ACCESS CAPABILITY REPORT

40-48 Redan Street, Mosman
Report No. ACR-25114-1 dated 23.06.2026

Prepared for:
Mosman Land No. 1 Pty Ltd

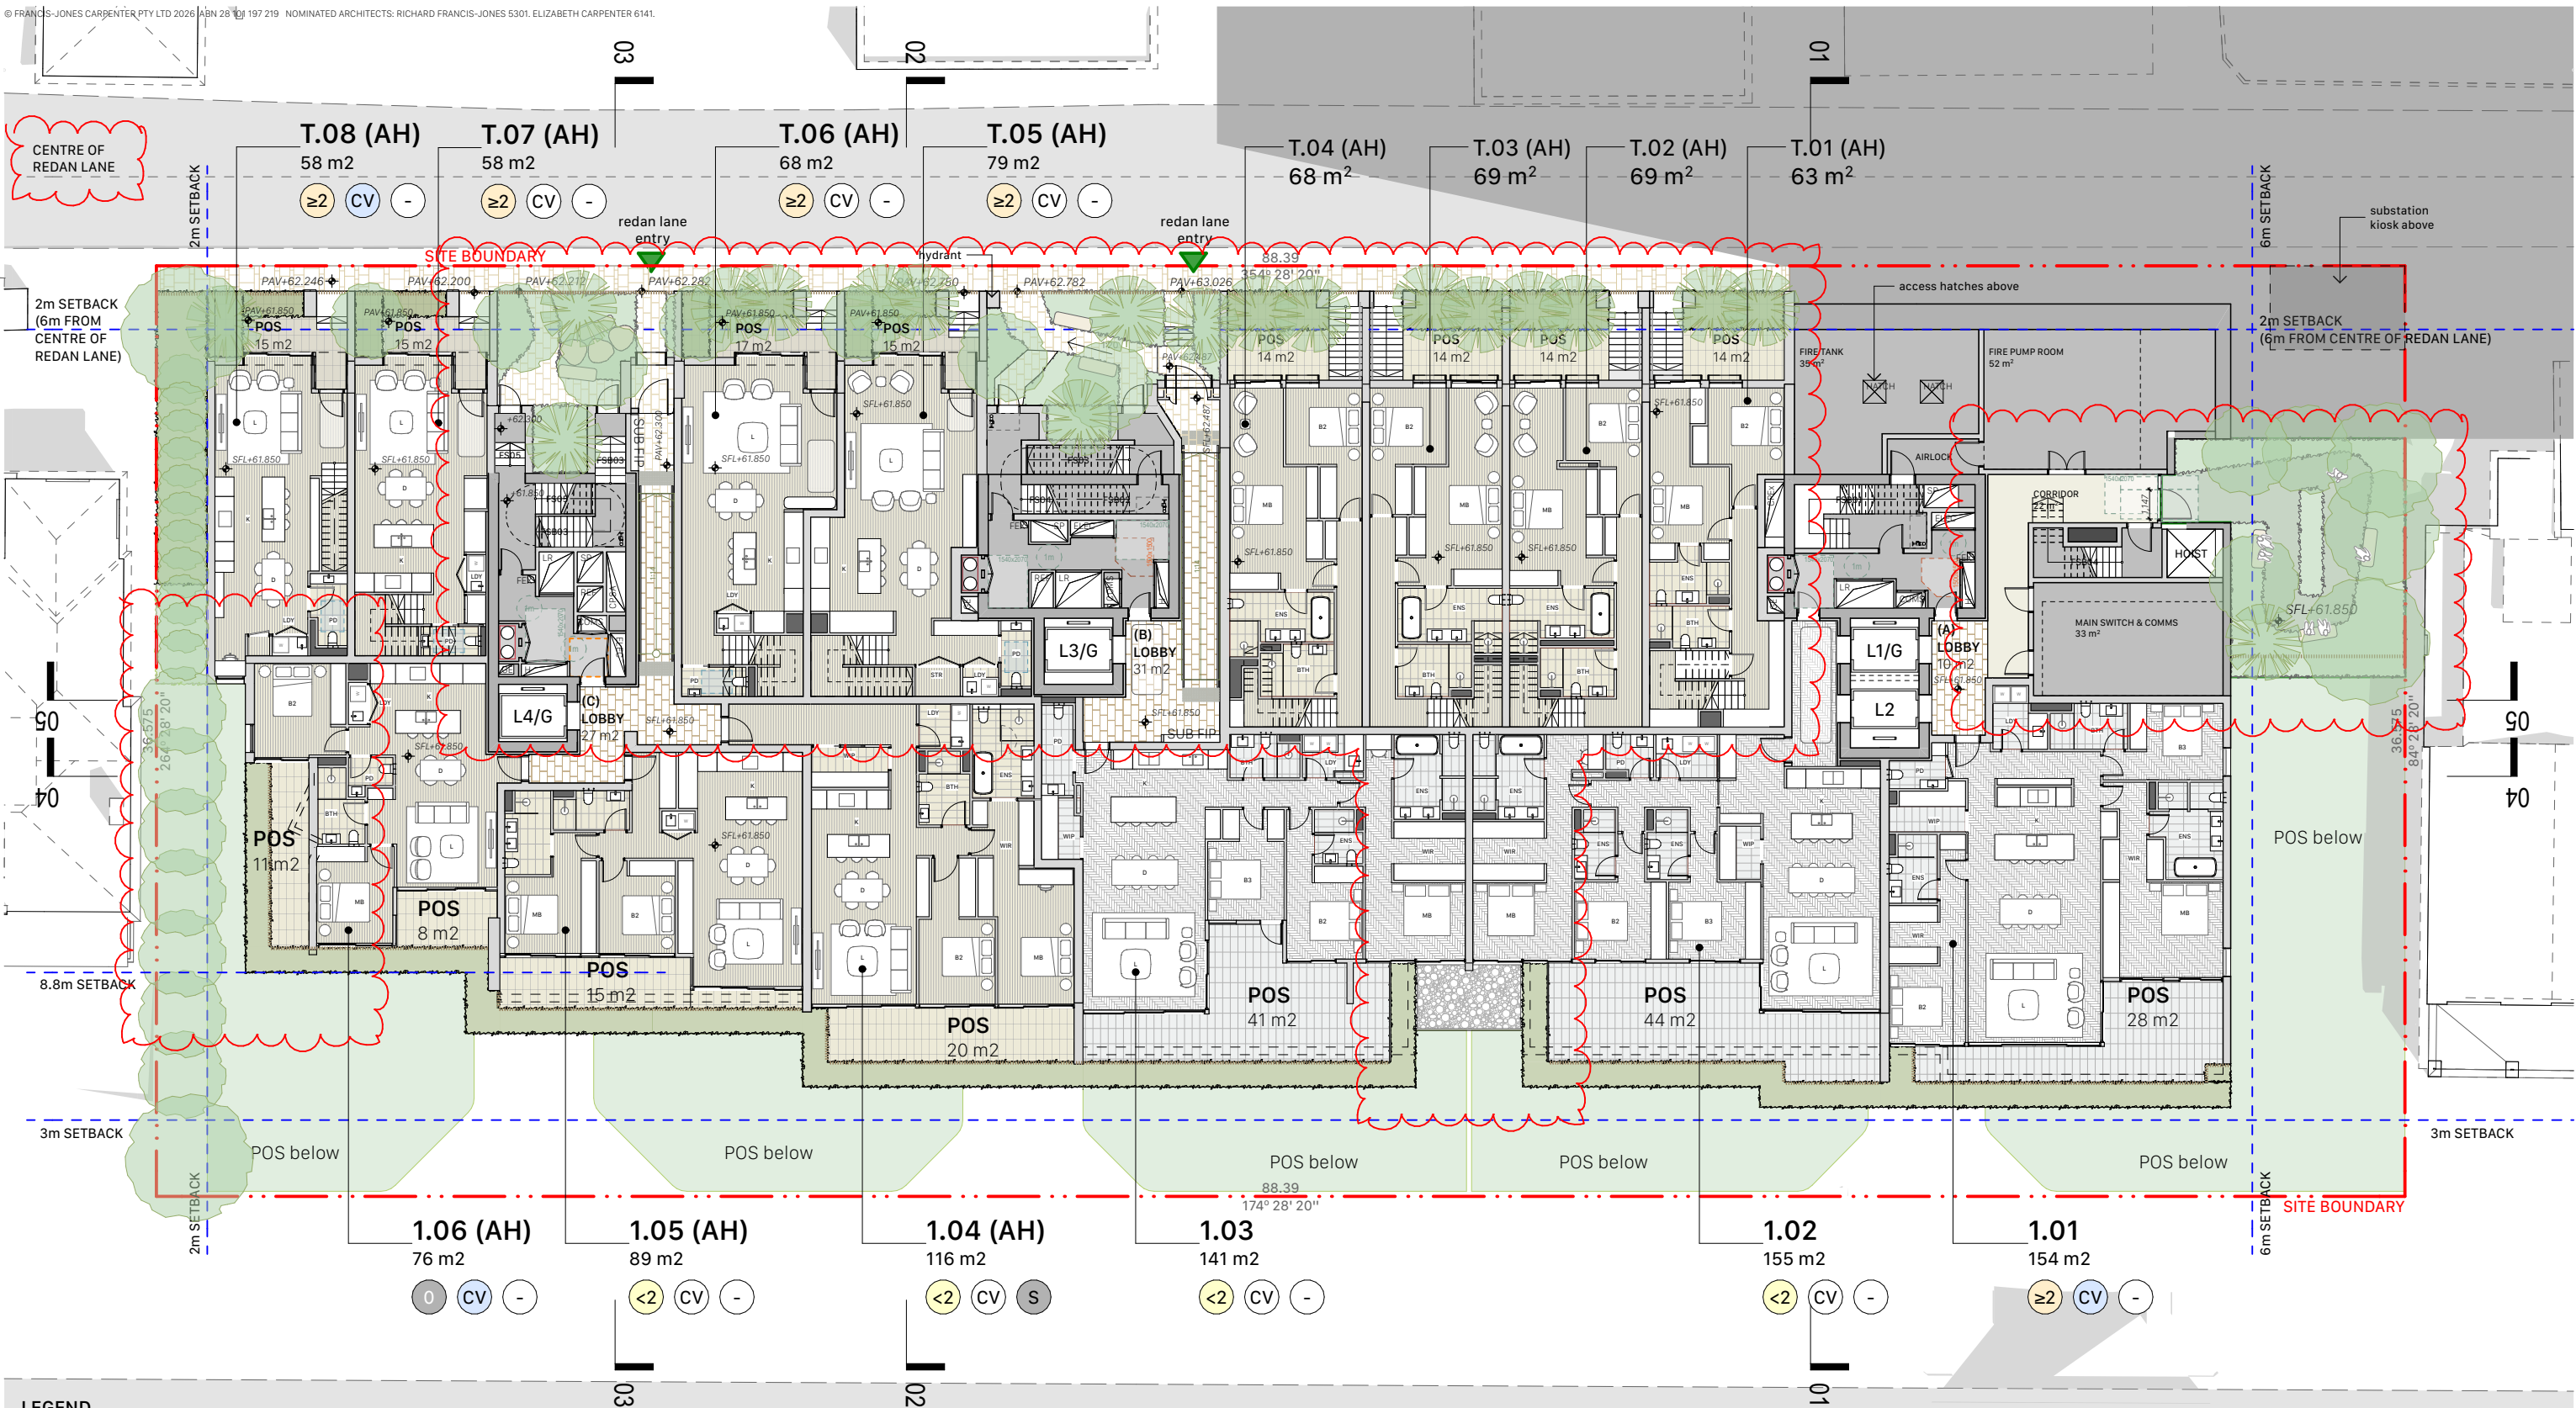
2.	D4D3	(a) The gradient of the walkway that is within the site boundary but outside the fenceline on Redan Lane is required to comply with AS1428.1 and requires further review to ensure it is not steeper than 1:40 at the gate circulation spaces, not steeper than 1:20 in the direction of travel and has a crossfall not steeper than 1:40. Landings also required to walkways between 1:20-1:33 at intervals in accordance with Clause 7.2 of AS1428.1. (b) 1:40 landings required at changes in direction associated with the accessways from Redan Lane to Lobby B on Level 1 and Lobby A on Level 2. (c) The circulation space of the pedestrian entry pivot doors to the common lobbies on Levels 1 & 2 is required to be amended to comply with Figure 31(d) & (h) of AS1428.1, or the doors are required to be power operated. (d) The circulation space of the pedestrian gate from Redan Lane to Lobby C on Level 1 is required to be amended to comply with Figure 31(d) of AS1428.1.

3.	D4D4	(a) All common ramps and external stairs not within an apartment are required to comply with AS1428.1. The stairs from Redan Lane to Lobby B on Level 1 & immediately to the north of the discharge door of FS01 near the entrance to Lobby A on Level 2 are required to be amended to ensure the required handrail extensions do not encroach on the adjacent accessways. (b) The corridor outside the entrance door to apartment 1.06 must be less than 2m or a 1540mm wide turning space will be required. (c) Confirmation to be provided if Lobby A on Levels 3-8 are common or form part of the title of the apartment they serve.
